Able Marine Energy Park

Material Change 2

Applicant's Response to

the MMO's D3

Figure 6.12: Later stage reclamation - Predicted peak increase in depth-averaged suspended sediment concentration above background over a spring-neap cycle

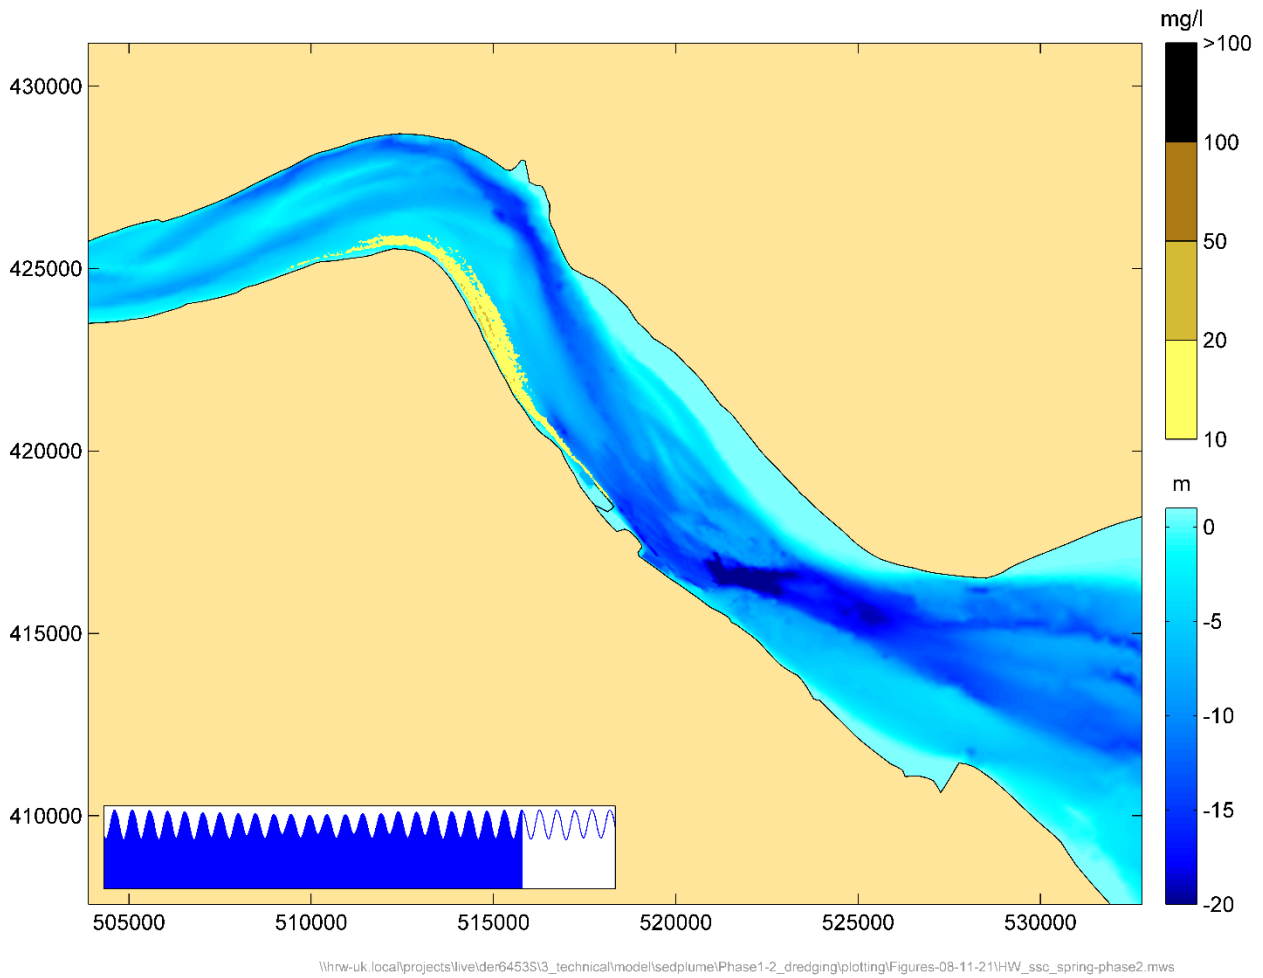
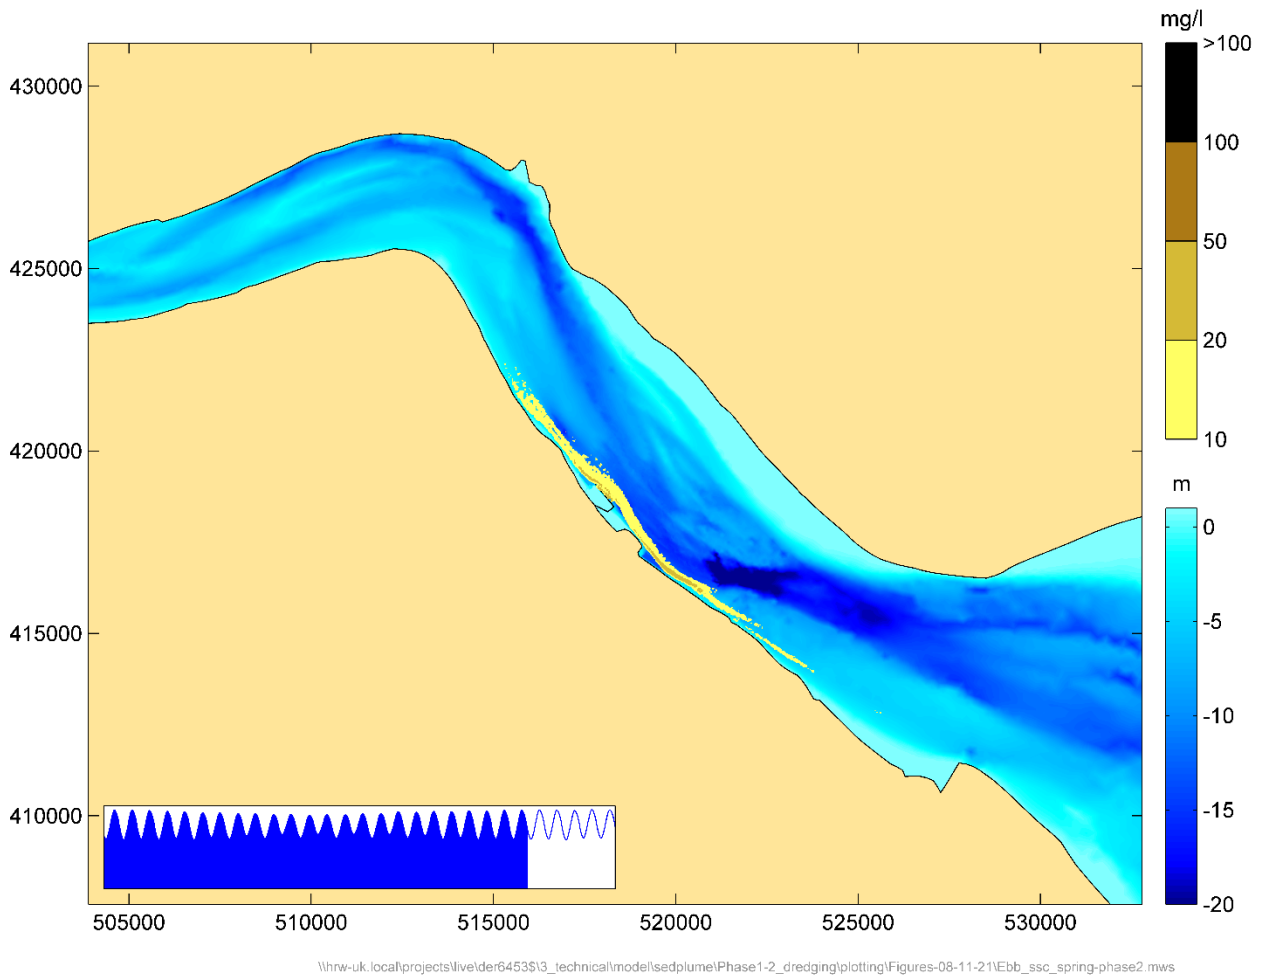
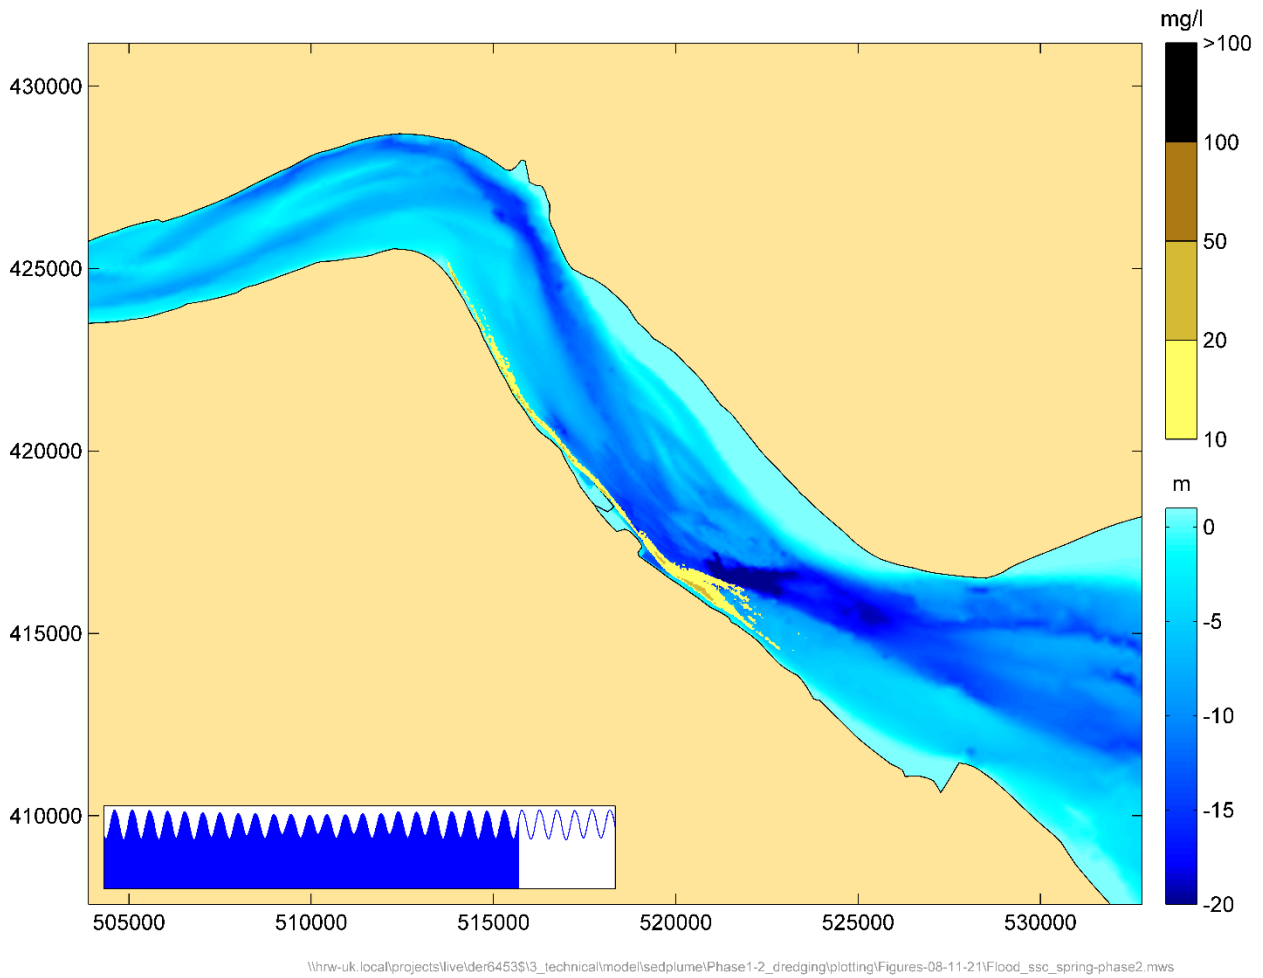
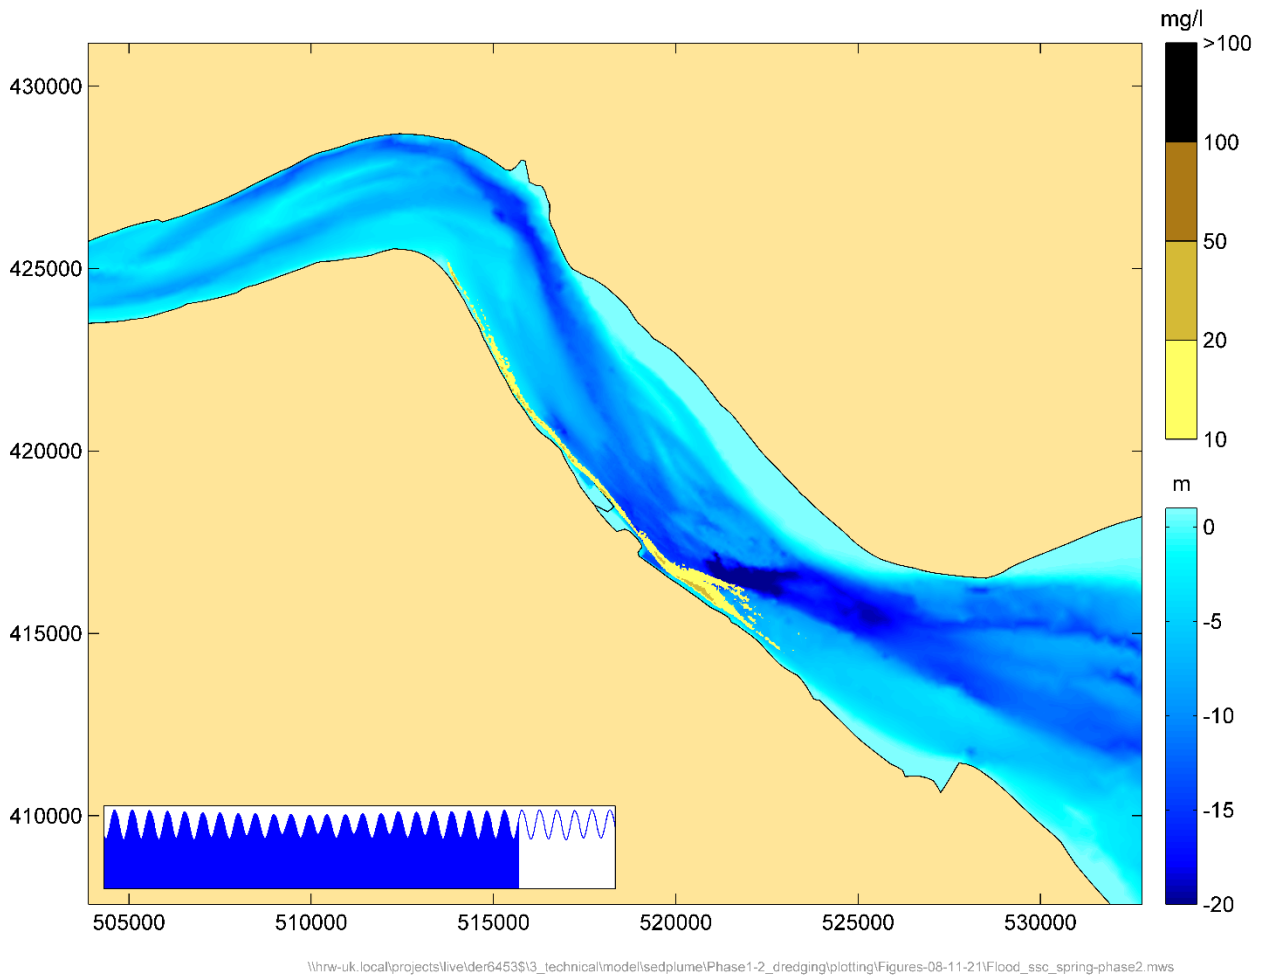
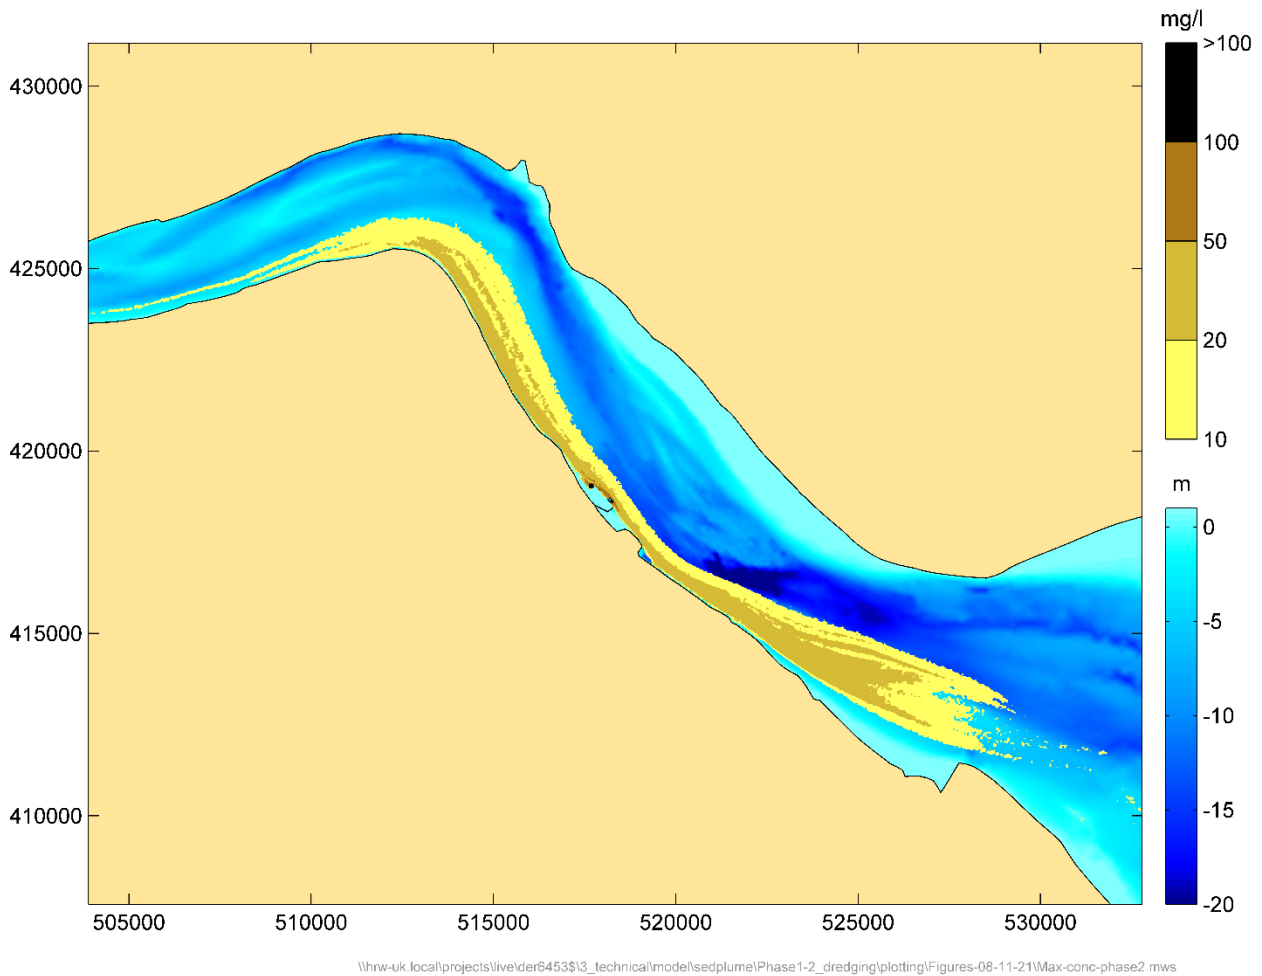
3.1 The MMO note that Sections 6.2.1 (early phase) and 6.3.1 (late phase) present data on depth-averaged suspended sediment concentration (SSC) increases, which indicate (absolute) increases over background of up to 50mg/l. The general conclusion is that the absolute increases are low in an estuary context. However, Section 4 (background SSC) lists peak SSC (at various estuary locations around the site) which the MMO consider would be more valuable presented as background values (while minimum values would be indicative of the potential worst case instantaneous change). It can be assumed that the works will occur at 'off-peak' times (i.e., dredging is not likely to occur in excessive weather/flow states associated with peak SSC) so the relative increase over background is not well represented. While the MMO appreciate that the peak value shows that very high SSC is not unusual in the location, comparison with the mean would make a stronger point with respect to the significance of the chronic effect.

The approach adopted in the HR Wallingford sediment plume report to the presentation of predicted increases in sediment concentrations arising from dredging activities is the same as in previous reports. Results are presented in the form of instantaneous plots of suspended sediment concentration levels above background levels at specific stages of the tide and as a plot of the envelope of peak suspended sediment concentration predicted over the course of the simulation period (a spring-neap cycle) regardless of the state of the tide.

Available information on measured concentrations in the vicinity of the AMEP site were described in HR Wallingford Report DER6453-RT002-R04-00, June 2021 and then summarised in this and previous reports to provide a context for comparison. The general conclusion for the dredging activities simulated is that the absolute increases are comparable to those previously assessed for the amended scheme with BHD loading barges and that the impacts are considered low in an estuary context. This is the important point arising from these further studies.

The MMO are suggesting that the peak SSC described may occur at times of excessive weather or river flow states and that dredging may not occur at these times. This is not necessarily the case for an estuarine environment. The factors most influencing SSC in the vicinity of the AMEP site will likely be tidal range, tidal surge; river discharge/rainfall and local wind wave action. It is not certain that any of these conditions, except perhaps exceedingly high winds, would affect the dredging activity (and as acknowledged, dredging vessels would be very unlikely to operate in such conditions in any case). The figure below (Figure 12 from UES Appendix UES9.3) shows the time measurements of suspended sediment concentration at two locations in proximity to the AMEP site measured over a year. The strong correlation with the spring-neap tidal cycle can clearly be seen, with elevated concentrations (typically peaking at 2,000 to 3,000 mg/l) at the time of spring tides and reduced concentrations at the time of neap tides (typically peaking at 200 to 500 mg/l).

Given the low levels of suspended sediment increase above background levels predicted to occur for the simulated dredging activity and the time varying nature of natural suspended sediment concentrations over the course of a spring-neap cycle it is not appropriate, in the view of HR Wallingford, to consider the plume concentrations, for this particular dredging activity, against the

mean measured concentrations. This approach was not requested by the MMO for other simulation results presented.
